Please ask for: Ms Iqraa Malik
Email: iqraa.malik@terraquest.co.uk
Telephone: 0121 234 1390
Our Ref: FP/251/21/PL
Your Ref:
Date: 4th January 2022

Application for Planning Permission

Development: Erection of single storey rear extension following the demolition of existing lean to.
Location: 5 Davenport Road Felpham PO22 7JP

DATE	REVISION	BY
5 Davenport Road Felpham Bognor Regis West Sussex PO22 7JP		
DRAWN RD	CHECKED	
SCALE 1:50	DATE 06.01.22	
PROJECT TITLE Proposed Extension to 5 Davenport Road		
DRAWING TITLE Proposed Ground Floor Plan		
DWG NUMBER 009	REV	
NEG NUMBER

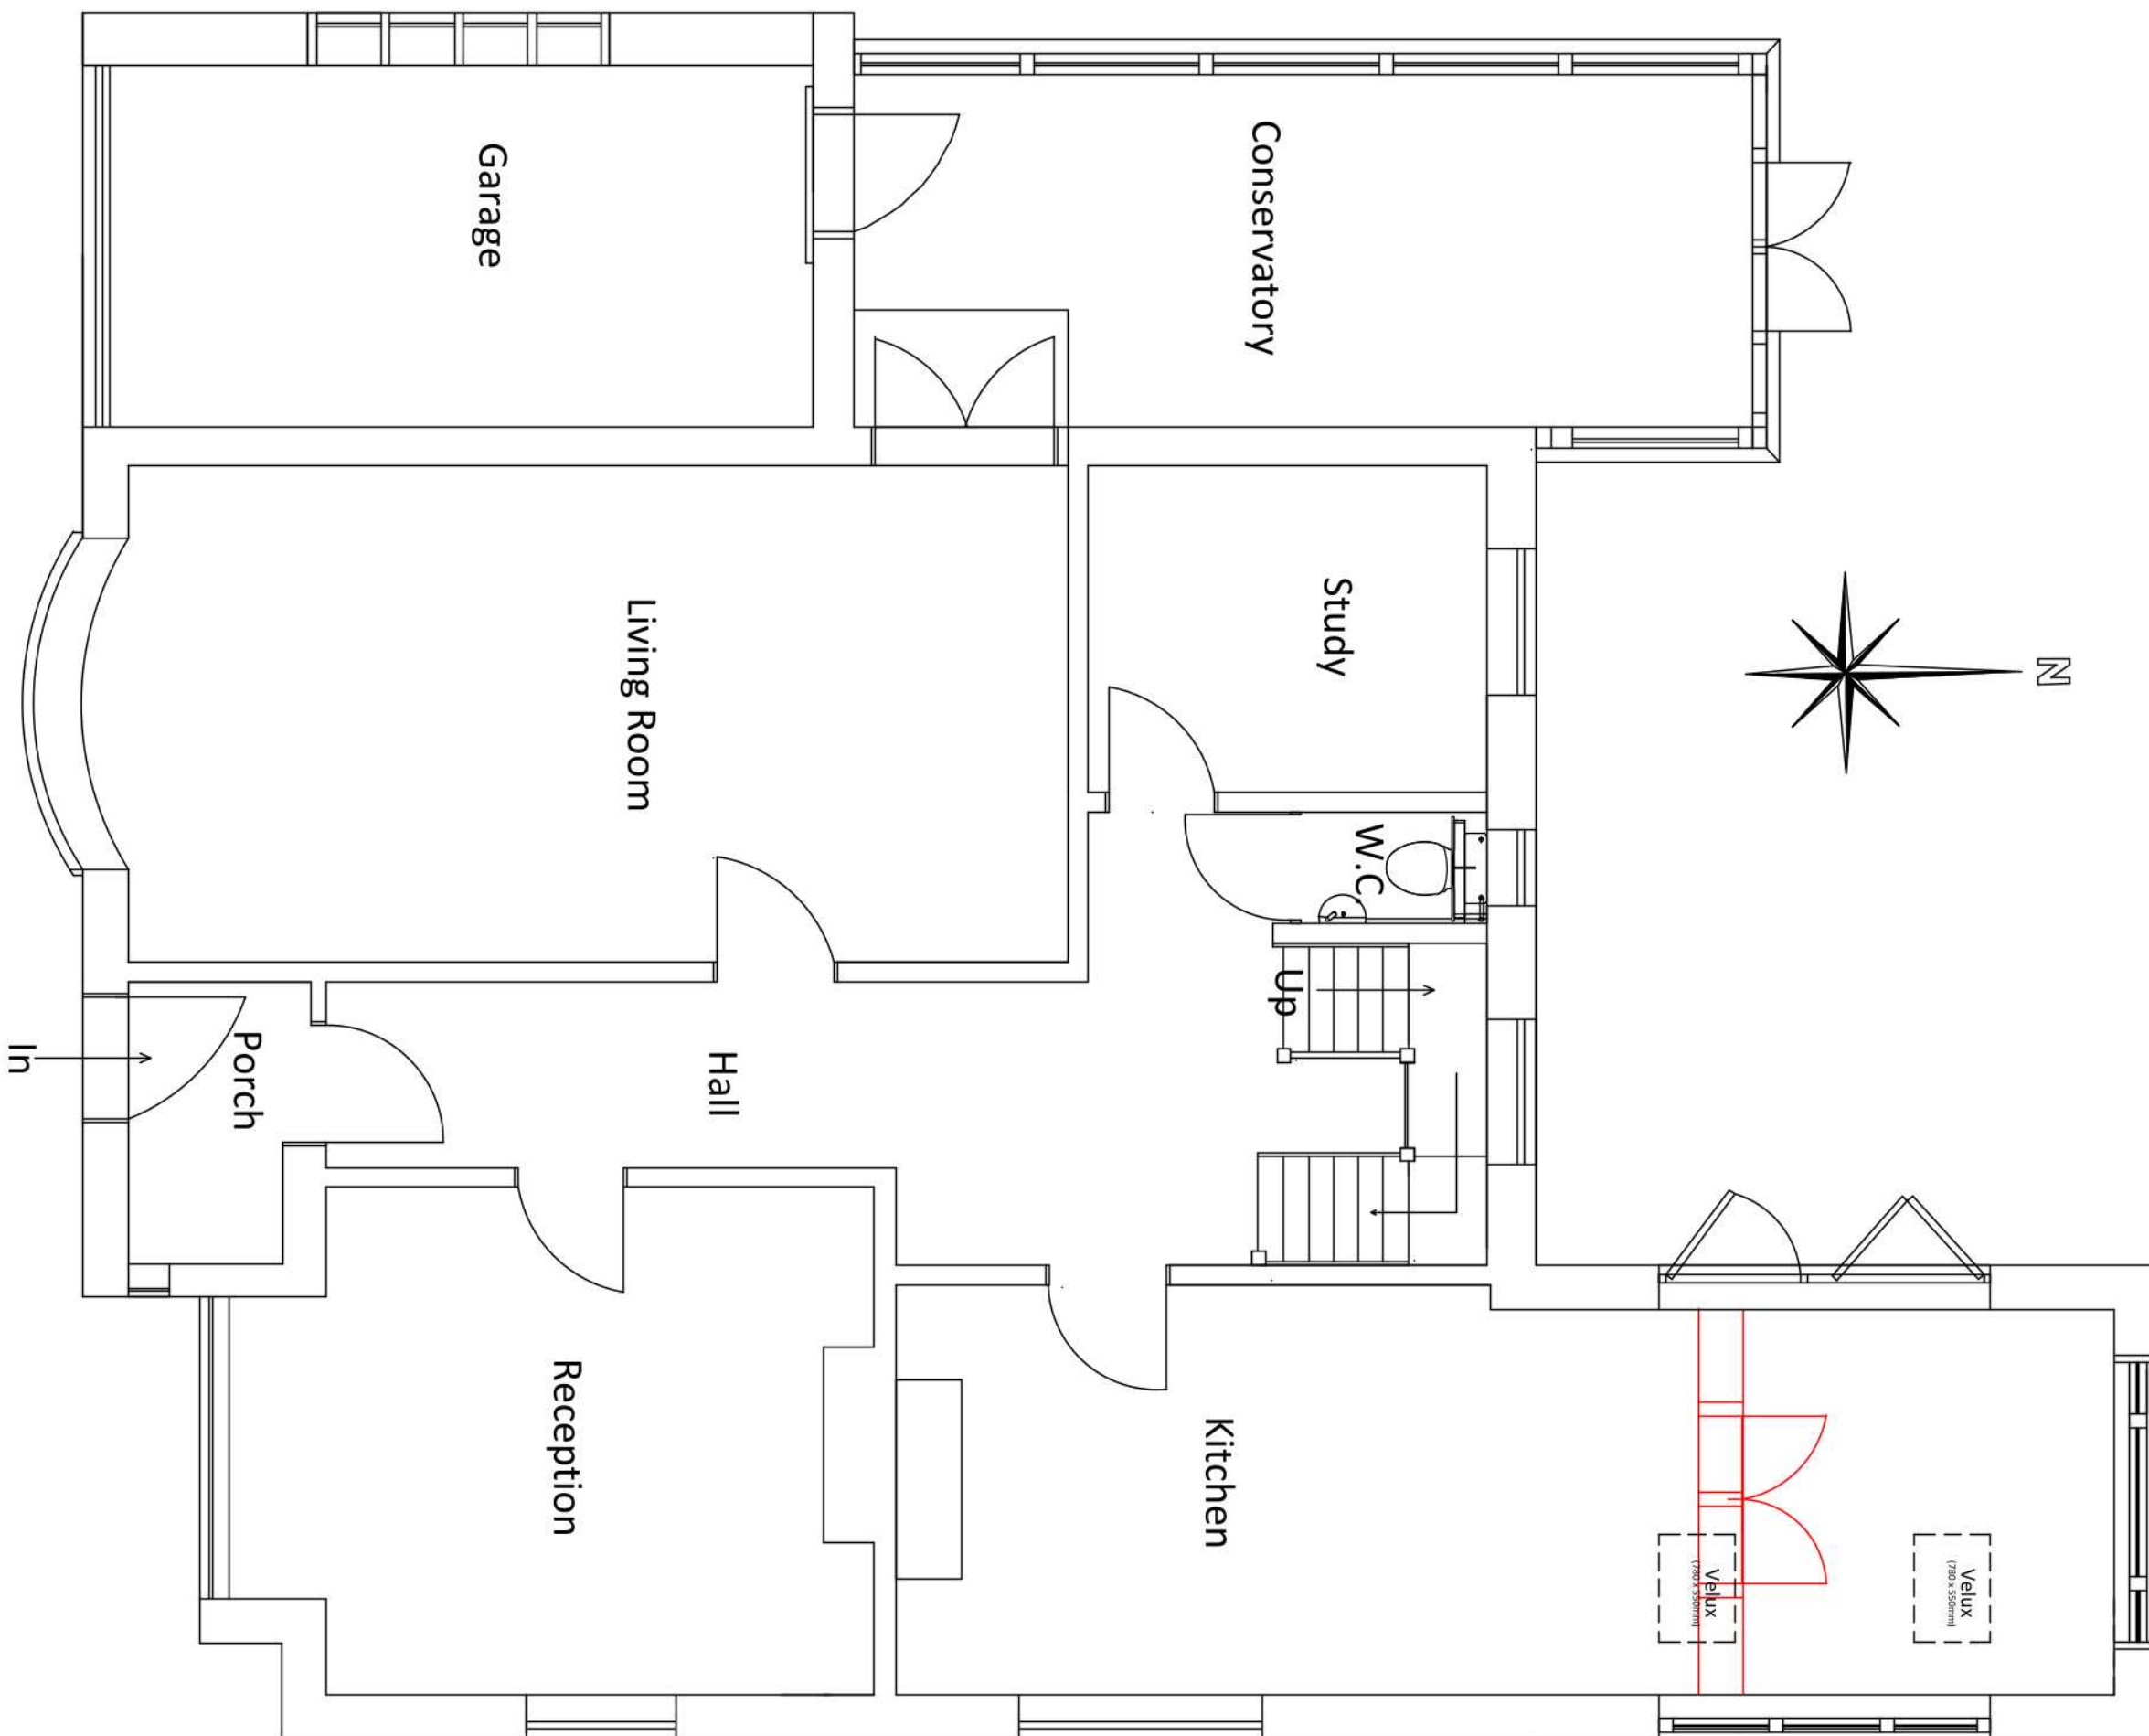
Please submit proposed elevations at a scale of 1:50 or 1:100. Along with this, the proposed floor plans require a stated scale. Further details can be found in the Validation Requirements List.
